## PLANNING CONSULTATION RESPONSE

<b>Application No</b>	2026/2044
<b>Proposal</b>	Demolition of existing building and septic tank and erection of new single storey community and sports pavilion, reconfiguration of parking, new landscaping and other associated works.
<b>Address</b>	Rabbit Ings Country Park, Lund Hill Lane, Royston, Barnsley, S71 4BB
<b>Date of Consultation Reply</b>	07/05/2026
<b>Consultee</b>	Claire Wilson, Planning Ecologist

Figure 4 Citation of Rabbit Ings Country Park Local Wildlife Site (LWS); Barnsley Metropolitan Borough Council

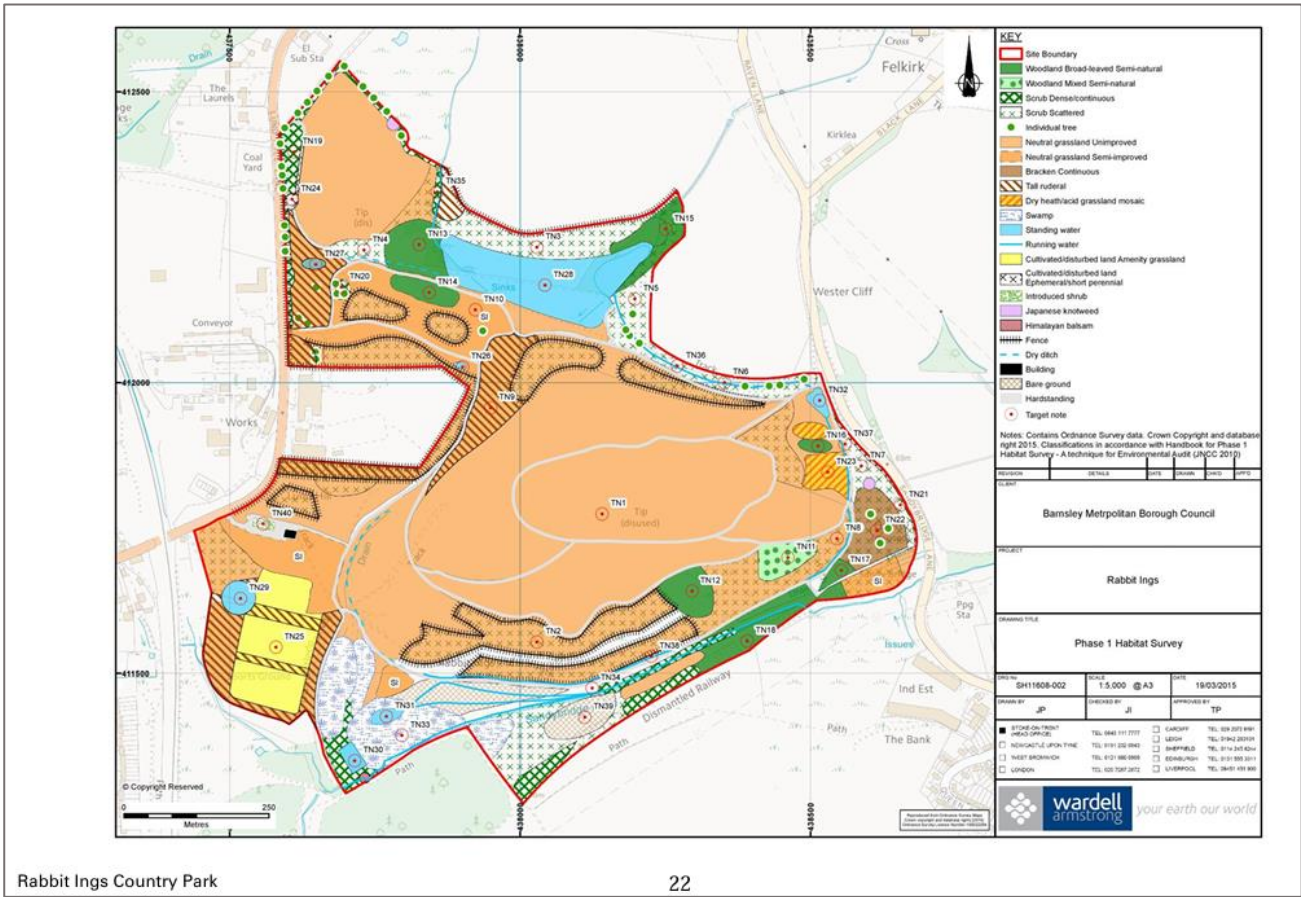
A data search with West Yorkshire Ecology Services has been undertaken, and this does provide some records for the site. However, it appears that a data search with the Barnsley Biological Records Centre (BBRC) was not undertaken. I do not consider this omission to be a significant issue in this instance; however, clarification is sought as to the reason for this. This would have also made the ecologists aware that the proposal site is located within Rabbit Ings Local Wildlife Site; this has not been considered within the PEA, and should be.
